**Notice of Exhibition  
Redevelopment of Parramatta West Public School (SSD 8790)  
Auburn Street and Young Street, Parramatta**

## **TAB A – Comments on State Significant Development application SSD 8790**

Figure 40: Proposed pedestrian crossing and pedestrian refuge in Franklin Street

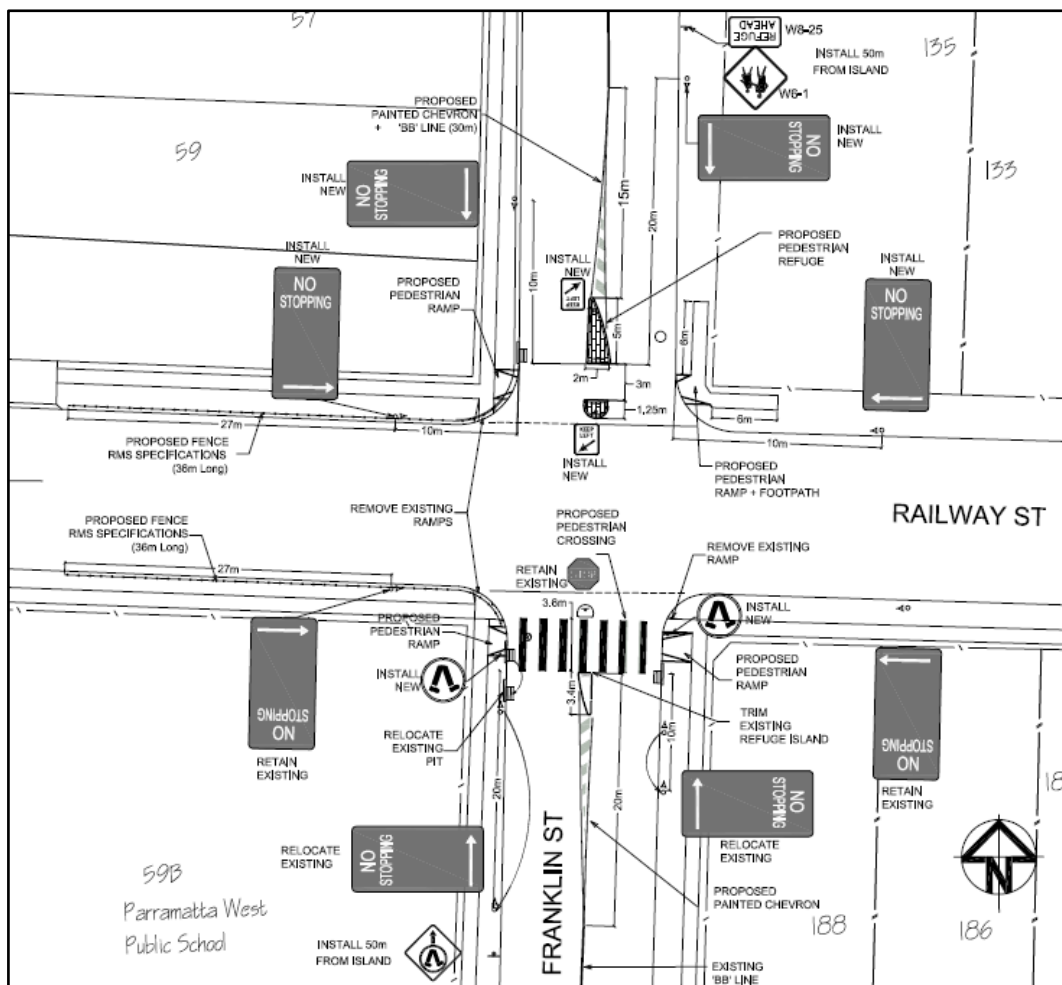
The Section 3.5 of the Transport Assessment (Arup, Aug 2018) identifies future pedestrian crossing facilities (1x pedestrian refuge and 1x pedestrian crossing) along Franklin Street at the intersection with Railway Street, which were approved by the Holroyd City Council in 2015. It was resolved that the implementation would be subject to funding obtained from Roads and Maritime Services.

The status of the application for funding should be provided as part of the EIS. There could also be merit to revisiting the funding application given the proposed expansion of the school.

The Applicant should consult with Roads and Maritime Services and Council regarding the status of the funding application for the proposed pedestrian facilities.

Figure A3: Construction Vehicle Routes

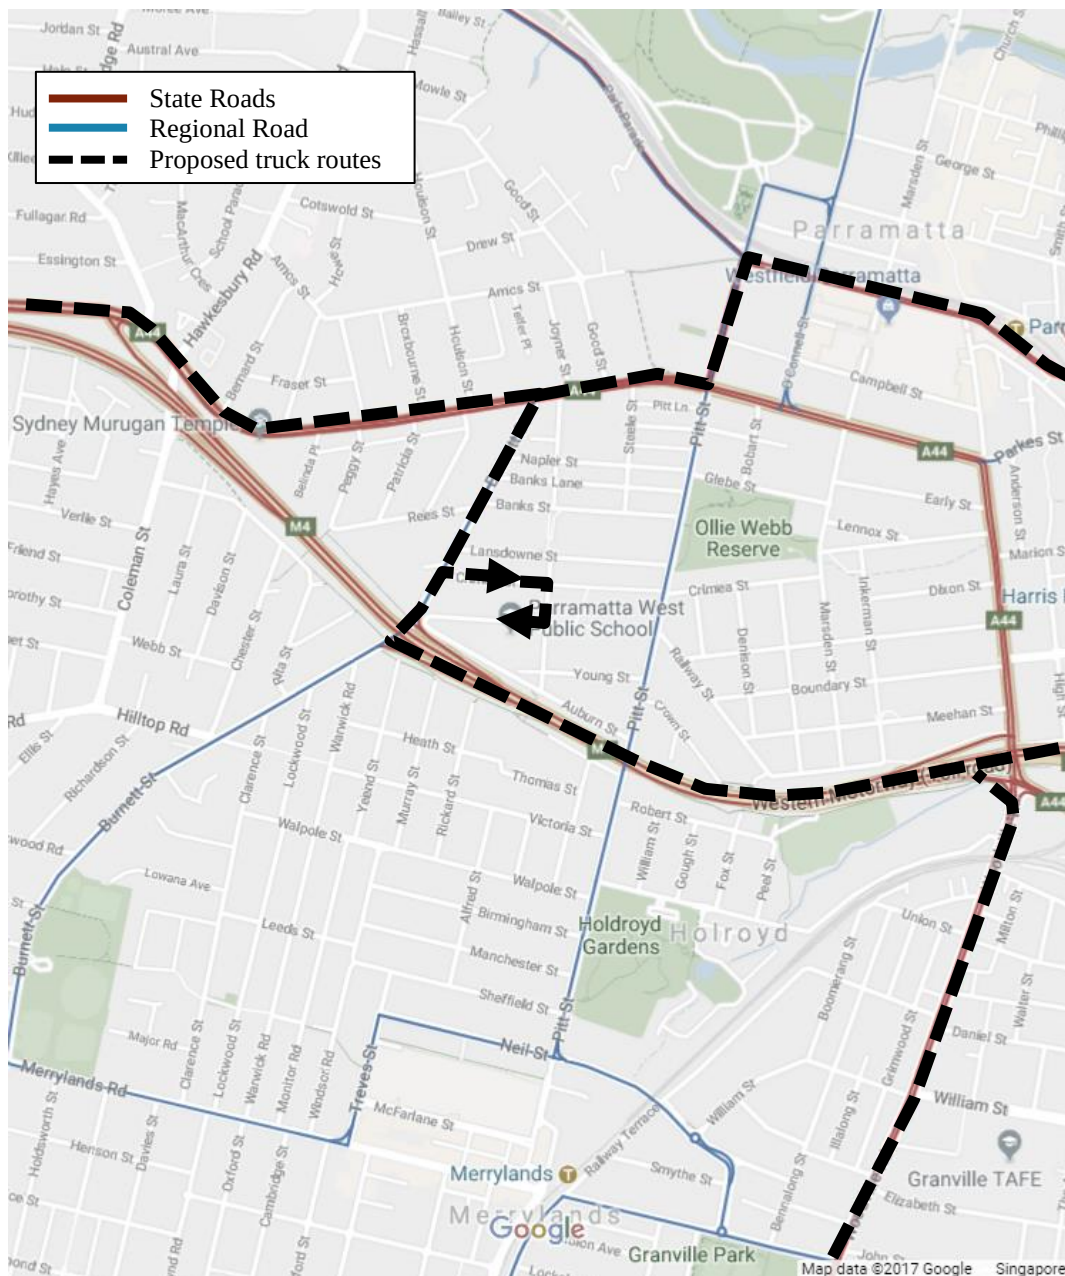
With reference to Figure A3 of the Transport Assessment, the proposed truck routes indicate that trucks intend to utilise part of the Liverpool-Parramatta Transitway fronting Parramatta Railway Station. The use of the transit way is limited to authorised vehicles and public bus services only.

The proposed construction vehicle routes should be revised having regard for access restrictions on certain roads within the area.
